**Re: Tract I-1 Mesa Del Sol, Innovation Park II
Grading and Drainage Plan
Engineer's Stamp dated 9-27-12 (R16/DA1003)**

Based upon the information provided in your submittal received 10-26-12, the above referenced report can not be approved for building permit based on the following comments:

SHEET NUMBER
C100

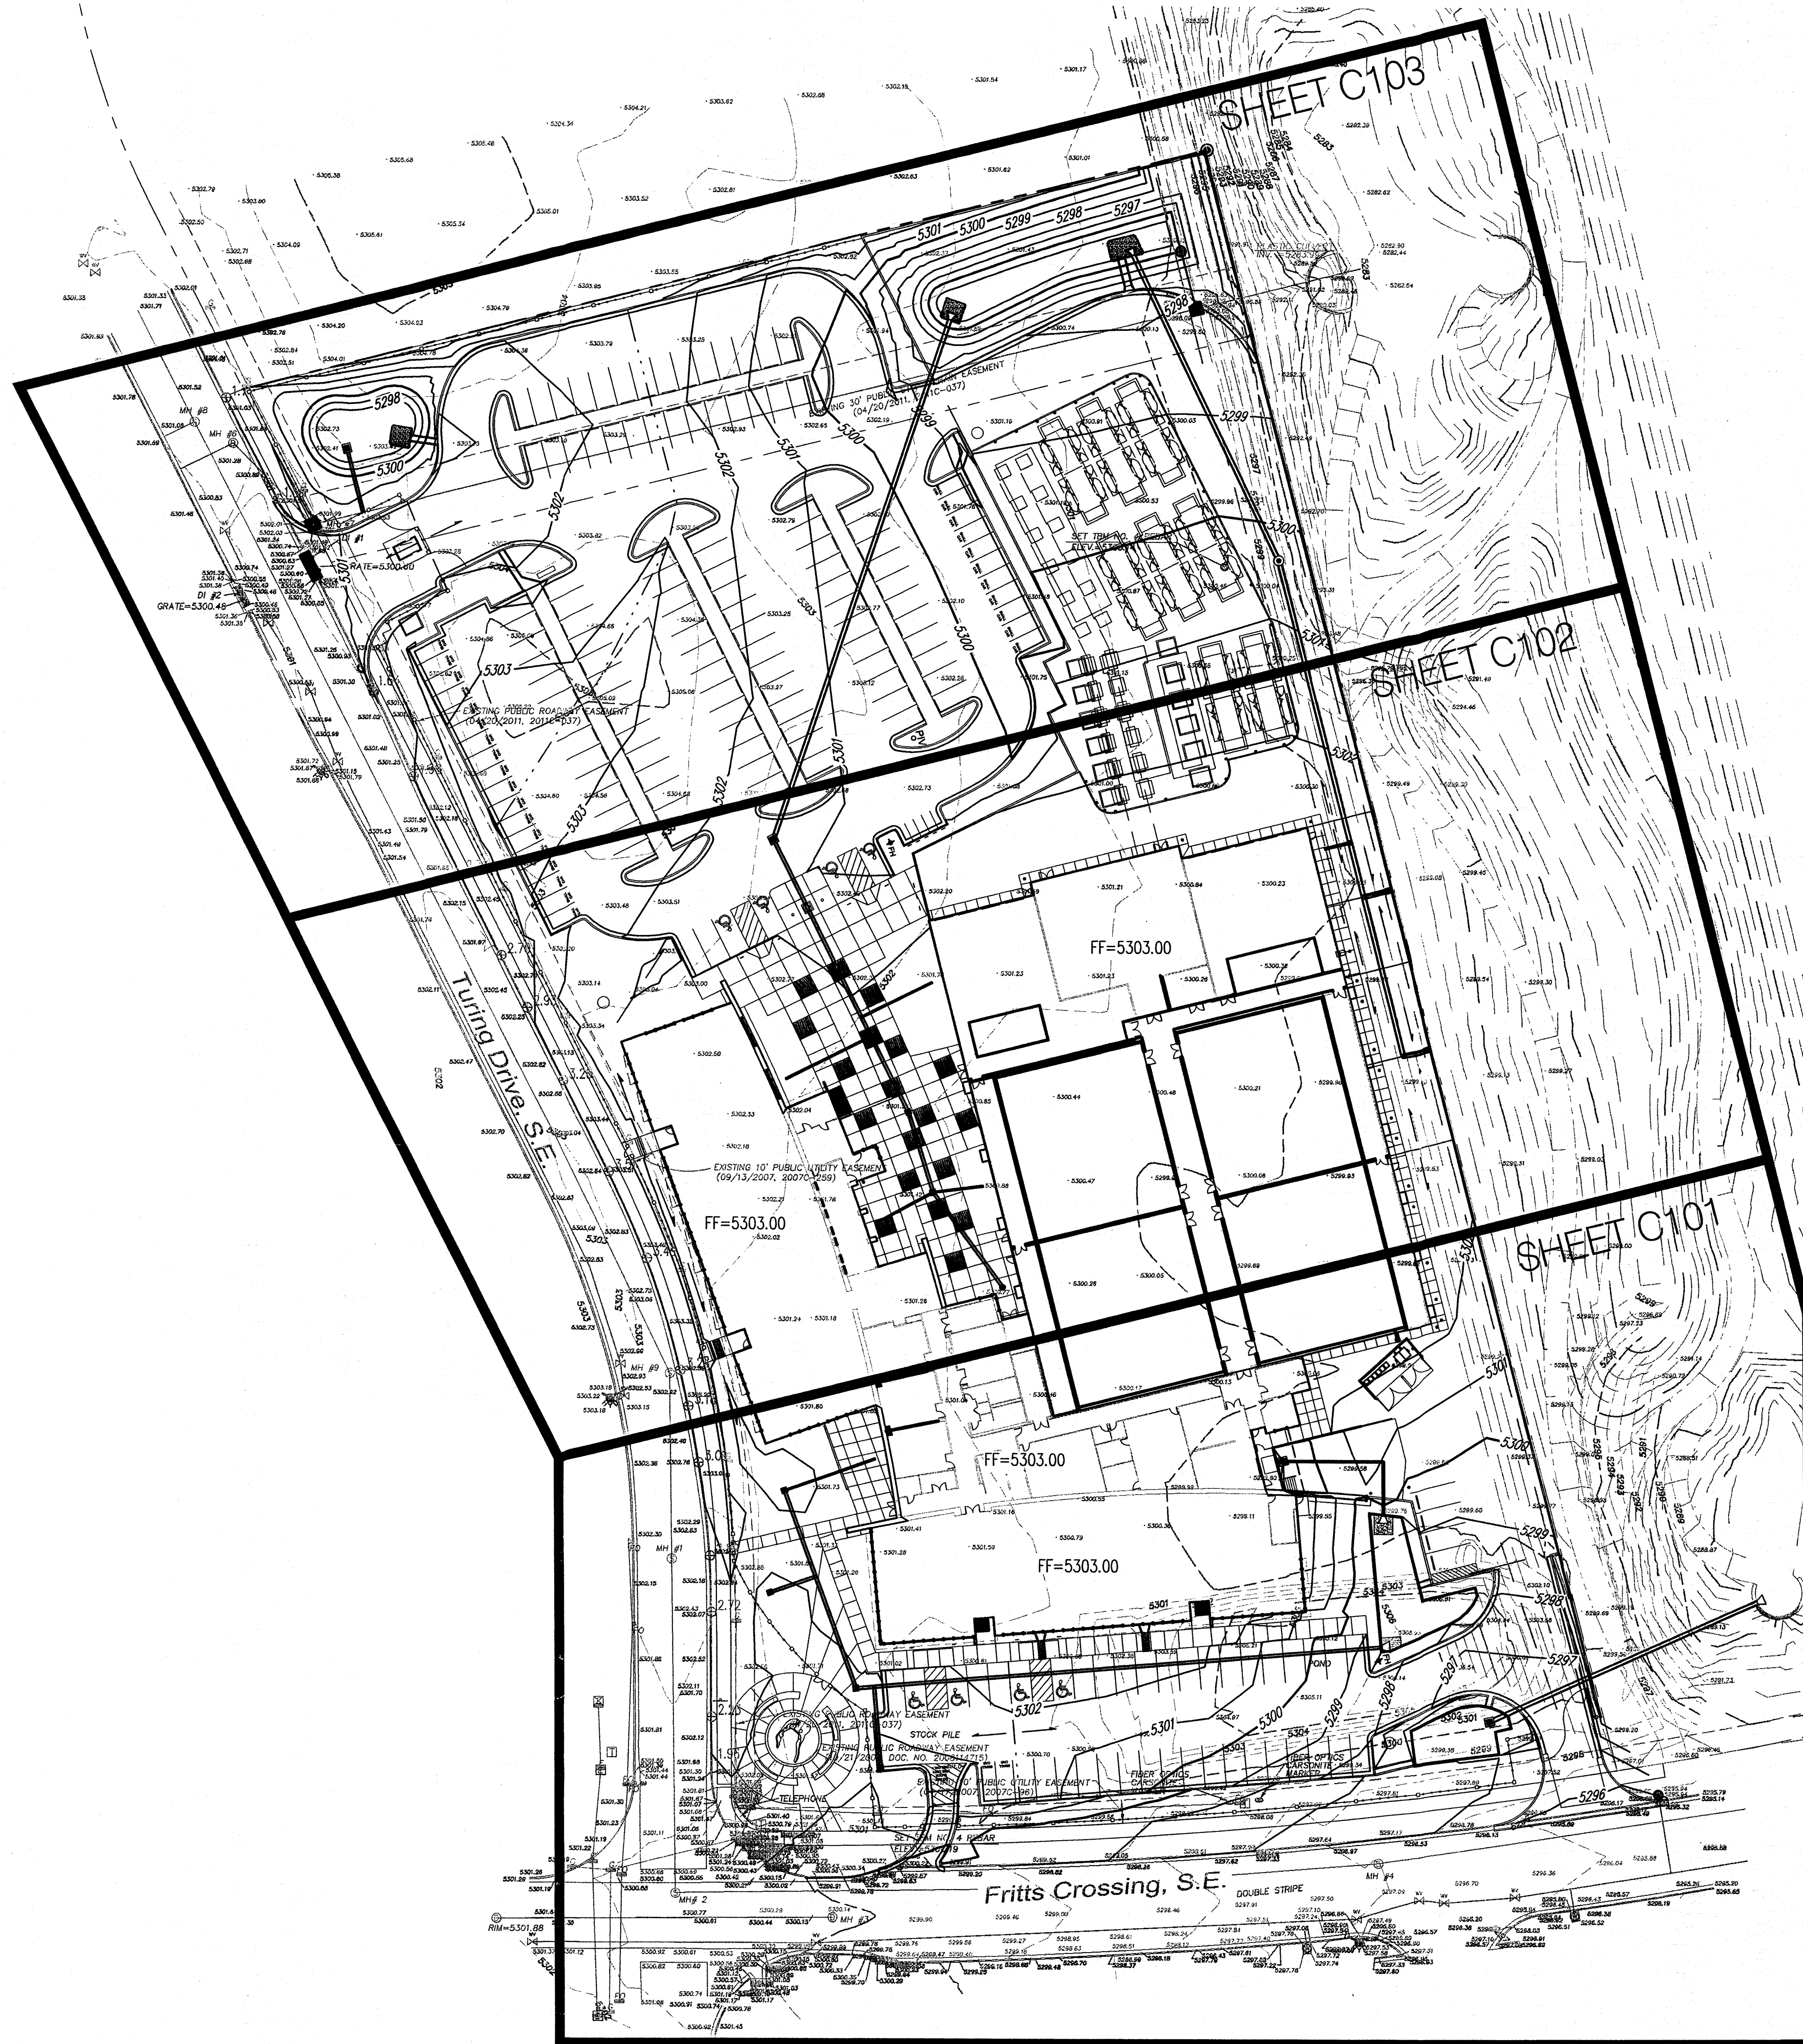
- Where will the excess dirt be placed from this project (if any)?
- Maintenance and covenant should be updated for any changes to the existing ponds.
- Clearly show the property line on the plans. Will the property be re-platted since northern portion of the project is on a different Tract? If not, proper easements should be provided.

- Two different existing contours are shown on the plans.
